DRB Application No.: **05DRB-01911 (P&F)**

Project # **1004390**

Project Name: **FRANCISCAN ADDITION**

RE: Franciscan Addition/p&f plat

PLAT OF
 LOT "1-A-1"
 FRANCISCAN ADDITION
 (BEING A REPLAT OF LOTS 10-23 AND "D" BLOCK 13)
 (AND LOT 1-A, BLOCK 12)
 (SITUATE WITHIN PROJECTED S.8 T.10 N. R.3 E., NMPM)
 (TOWN OF ALBUQUERQUE GRANT)
 ALBUQUERQUE, BERNALILLO COUNTY, NEW MEXICO
 DECEMBER, 2005

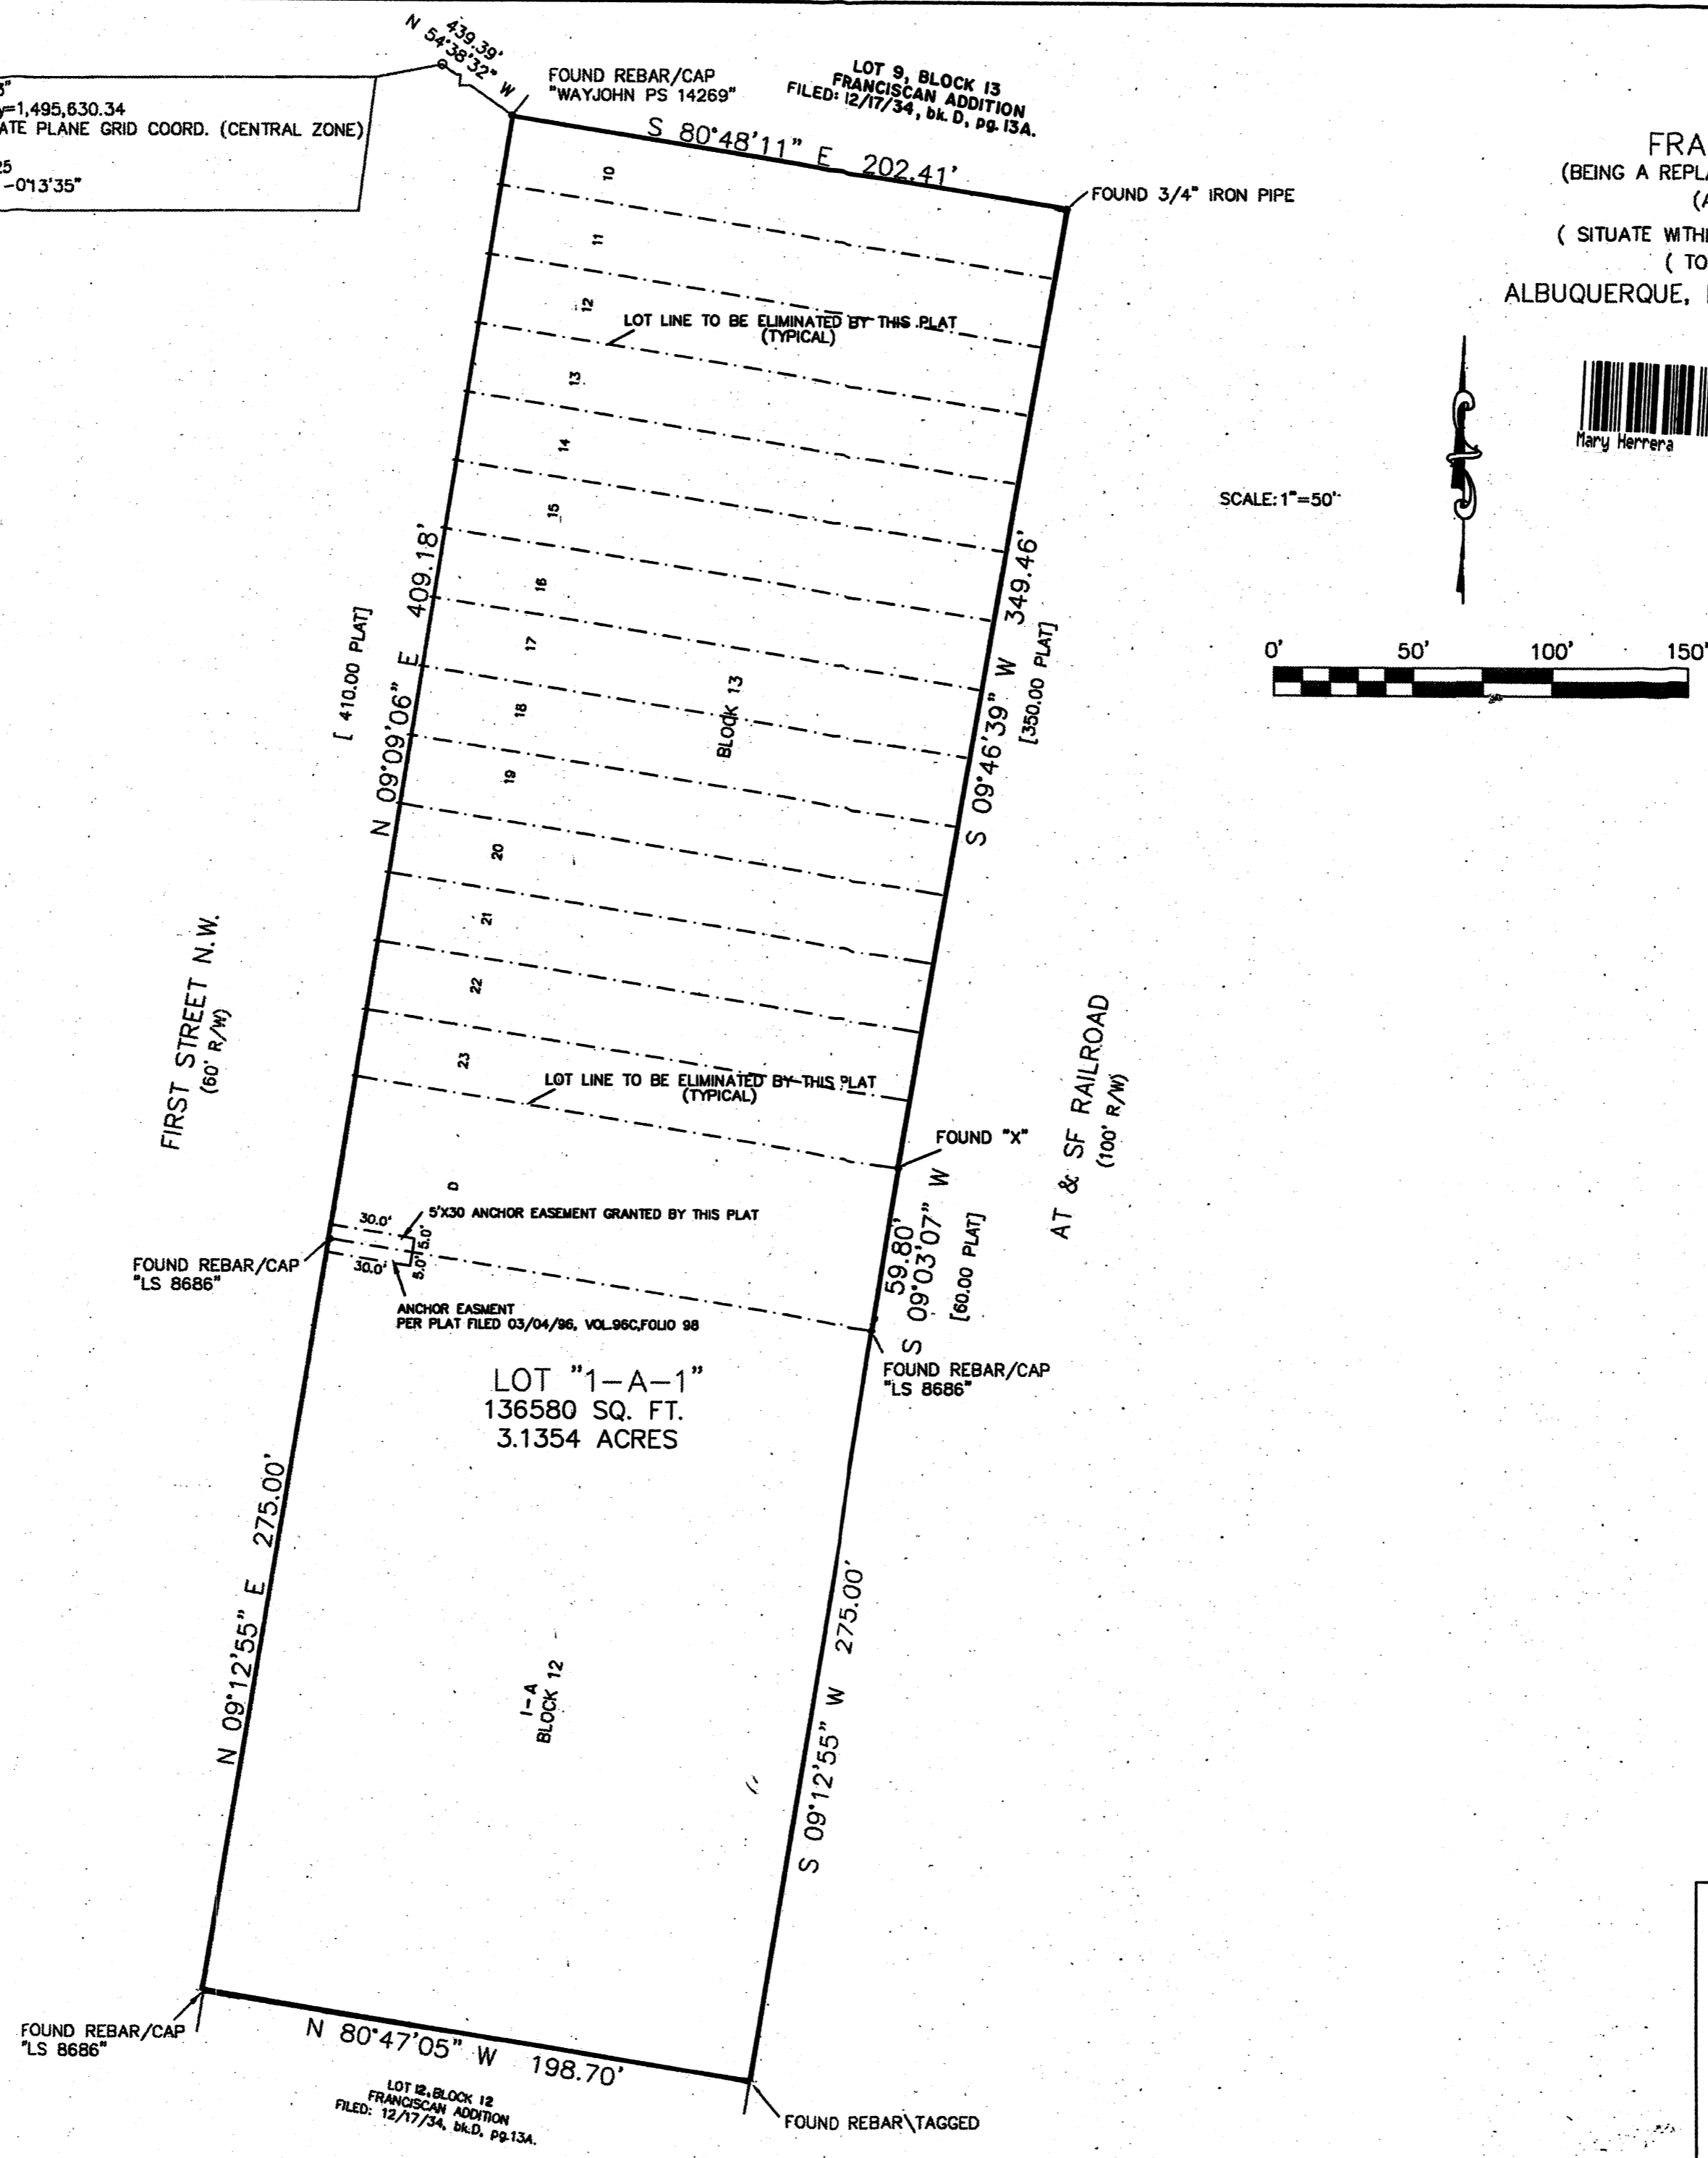
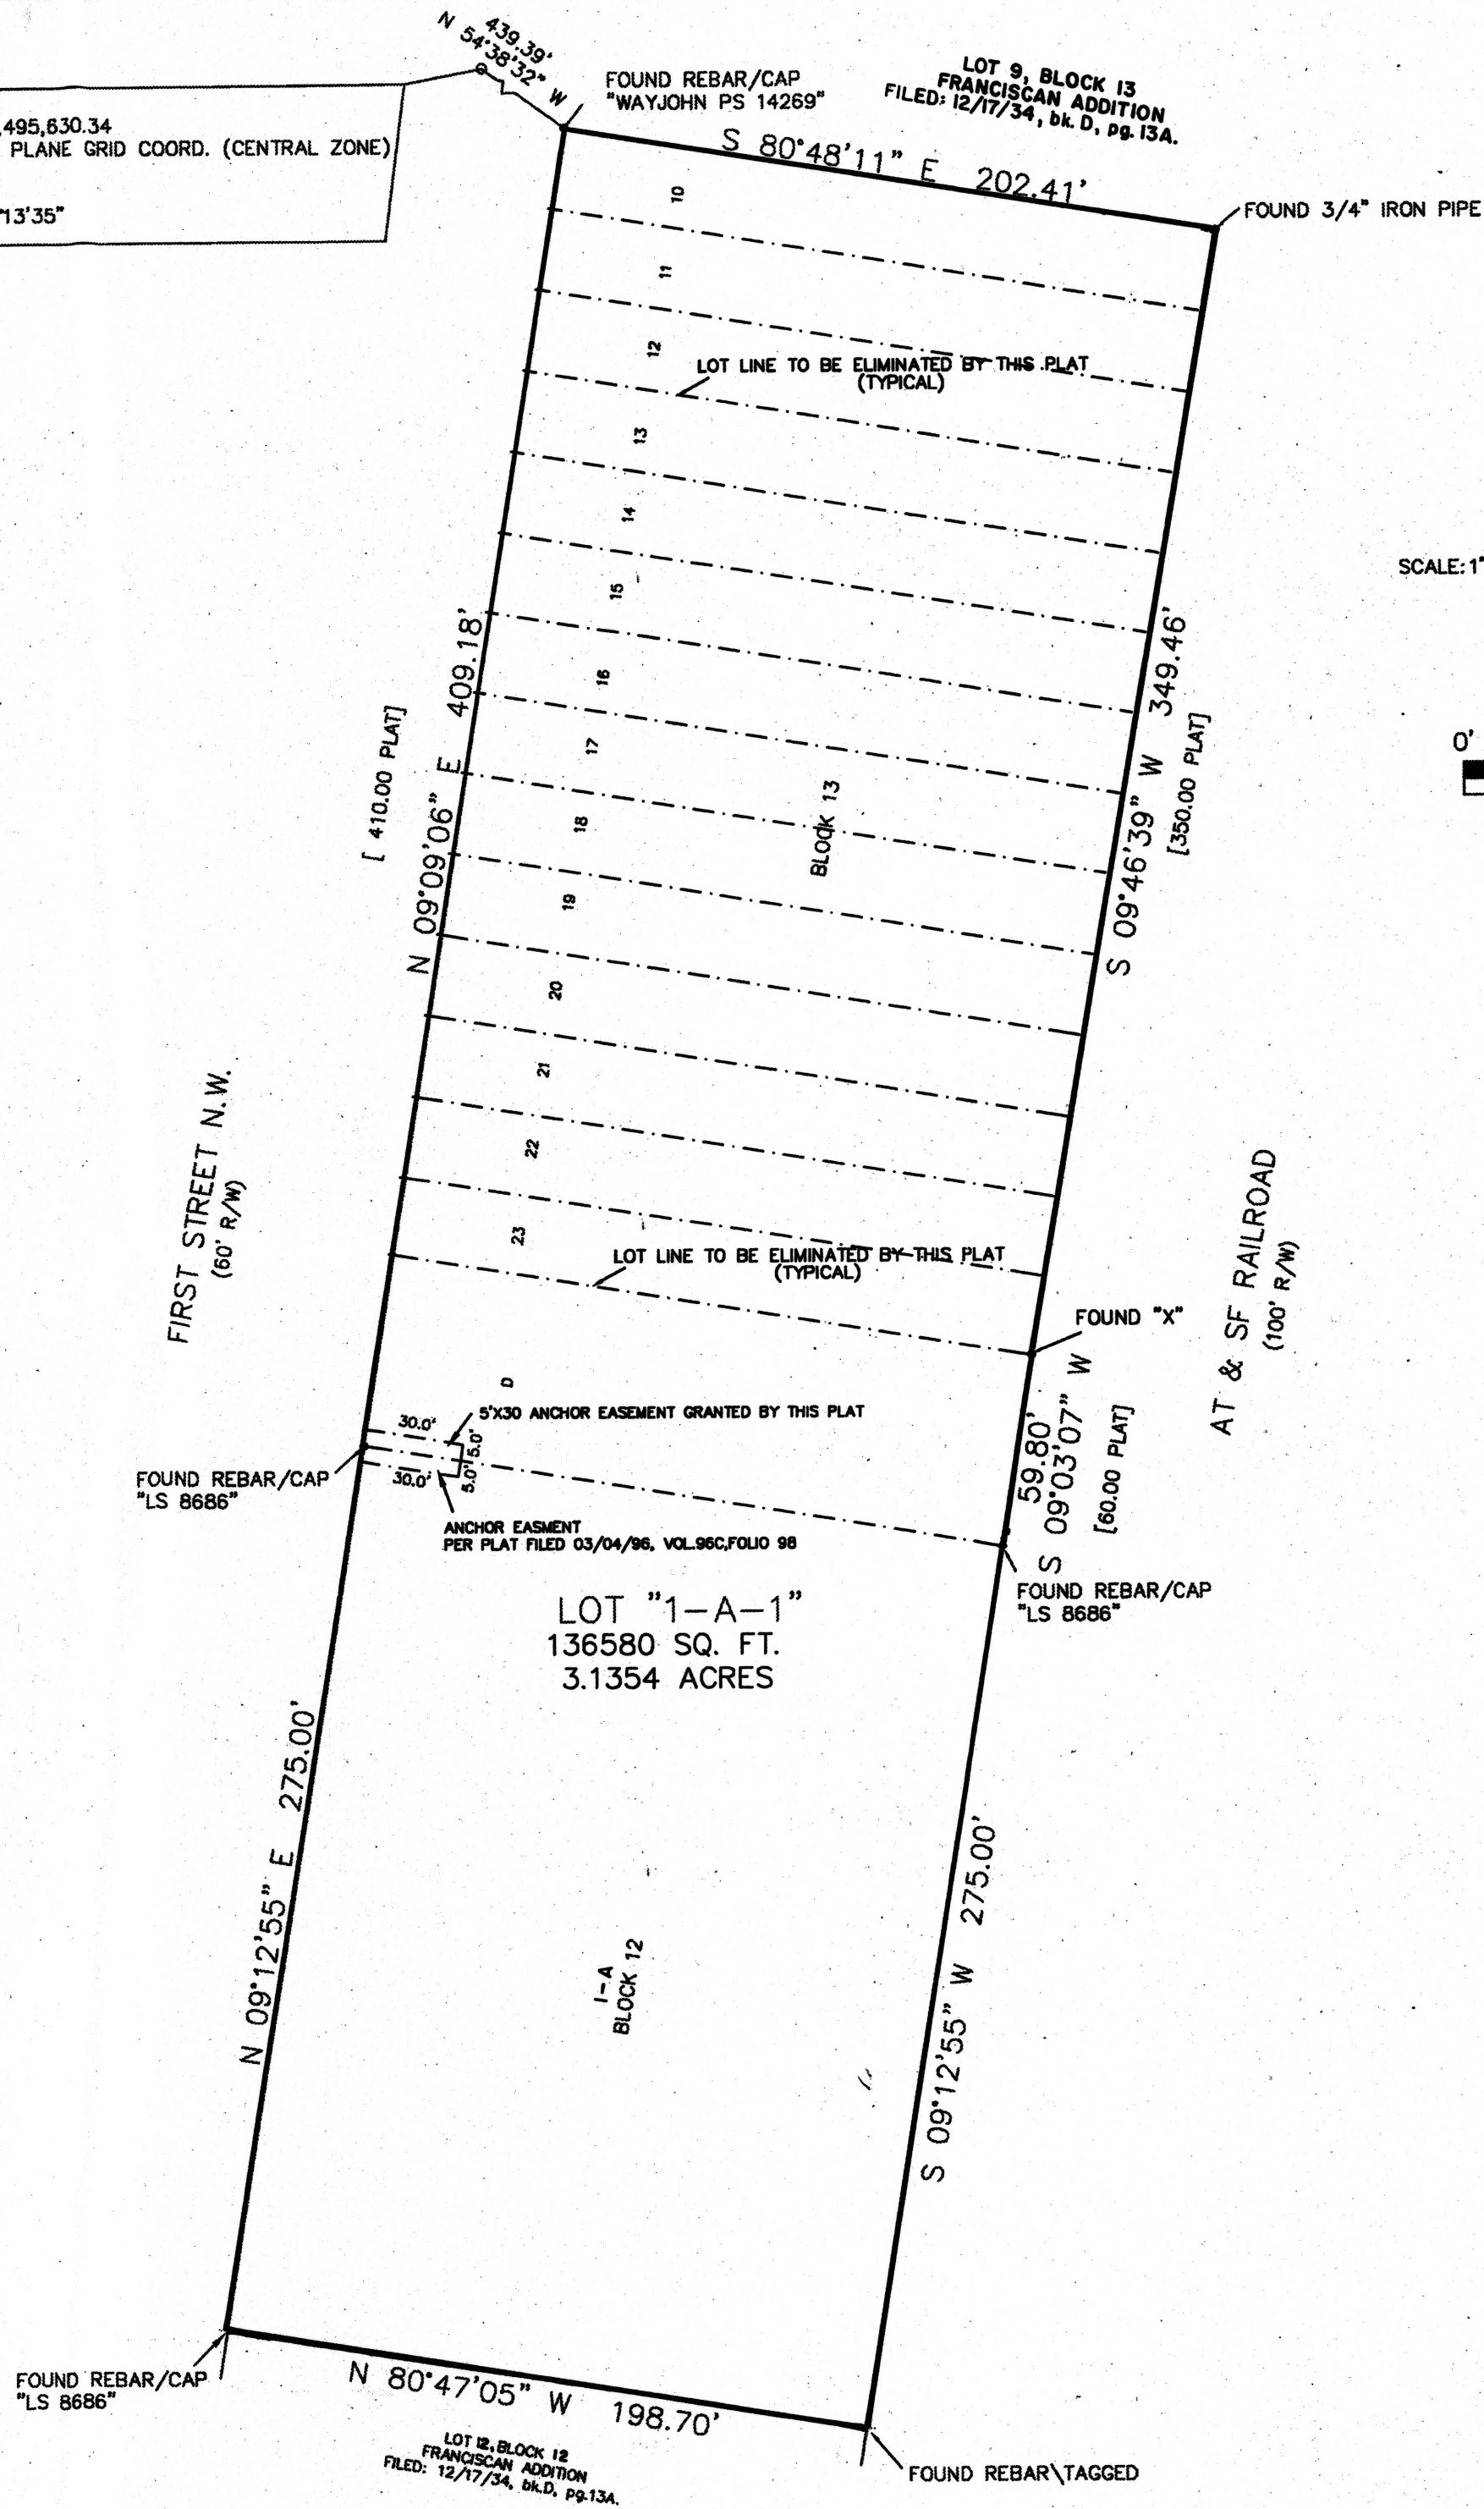
The zoning designation is missing in the subdivision data.

The signature block is not the correct one. The mylar must have the correct signature block to avoid deferral. Agent was contacted by voice mail on 1/03/06.
